SECTION 96a NON-MATERIAL CHANGES TO PLANNING PERMISSION 21/04144/F AT JACOBS DOUWE EGBERTS, RUSCOTE AVENUE, BANBURY, OX16 2QU

On behalf of our client, Jacobs Douwe Egberts Ops GB Ltd, we hereby submit a Section 96a planning application to make non-material amendments to planning permission 21/04144/F.

**Proposed CS North and South Elevations**

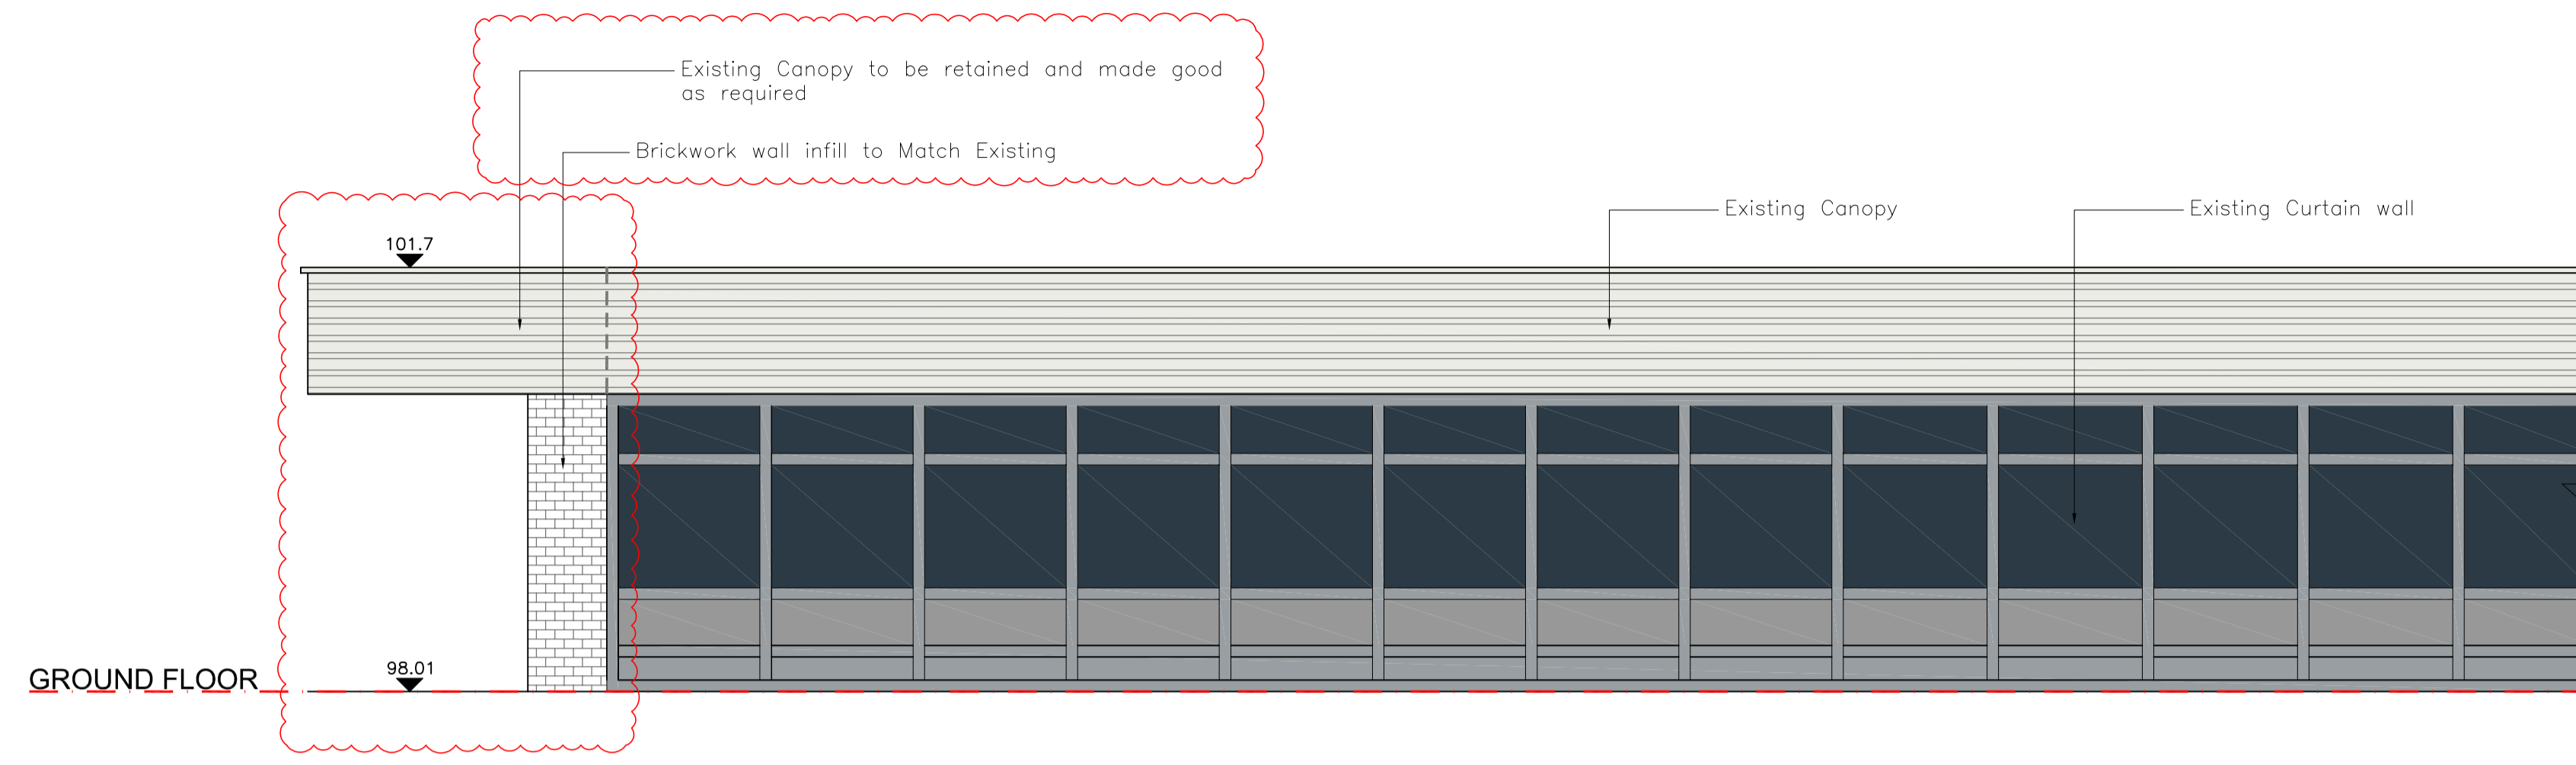
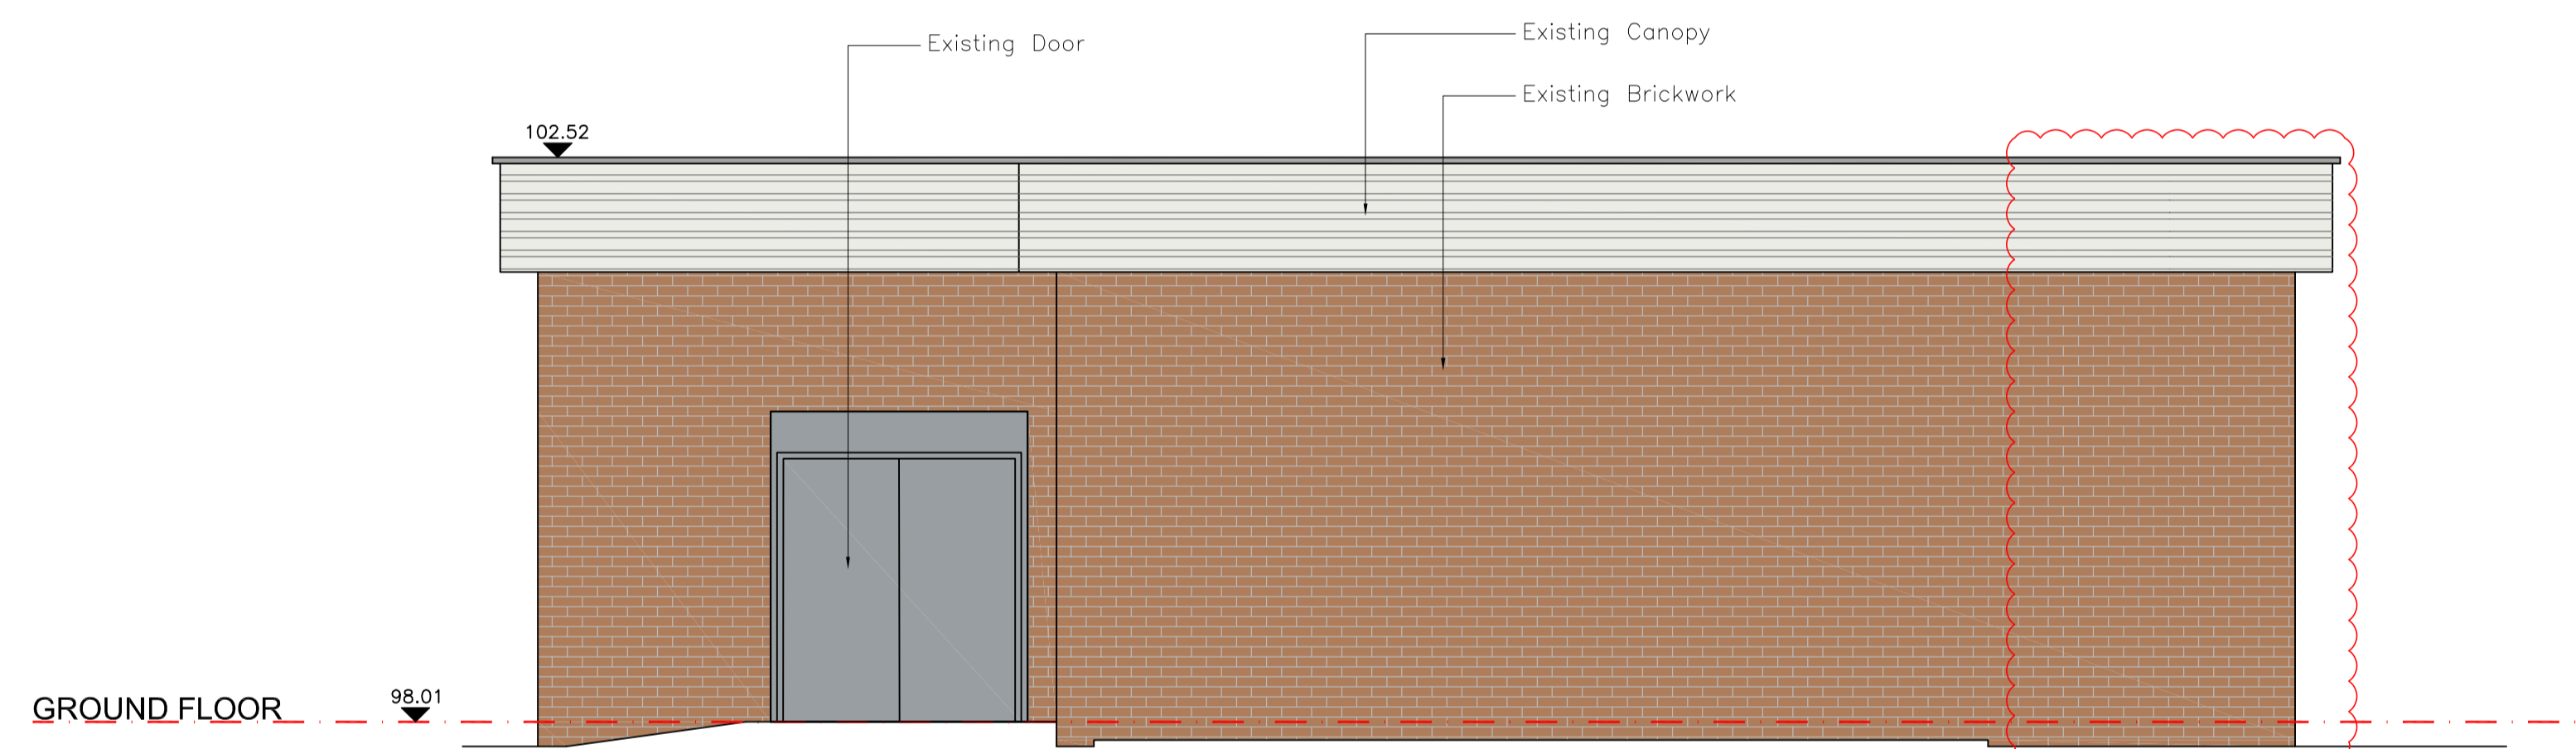
Following the grant of planning permission, the client has progressed further with the detailed design of the elevations of the computer suite. After an internal review, a decision has been made to no longer propose the external metal cladding and instead to block up the existing computer suite walls where the demolition of the office building has occurred with facing bricks to match the existing external materials of the computer suite.

The proposed metal cladding system had been proposed to add interest to the elevations of the computer suite following the demolition of the office building. The approved elevational drawings show the retained computer suite to be clad with profiled metal sheeting. After a further design review, it became clear that to achieve a design that is more in keeping with the existing brick computer suite, a more suitable elevation design would be to block up the walls that had been impacted following the demolition of the office building with facing bricks to match the existing brick building.

The proposed amendments to the elevations do not result in the nature of the proposed building changing. Indeed, the proposed brickwork will match the existing computer suite materials instead of introducing a new material to the external appearance. Furthermore, the amendments do not have any impact on neighbouring properties, nor would they warrant re-consultation with any party.
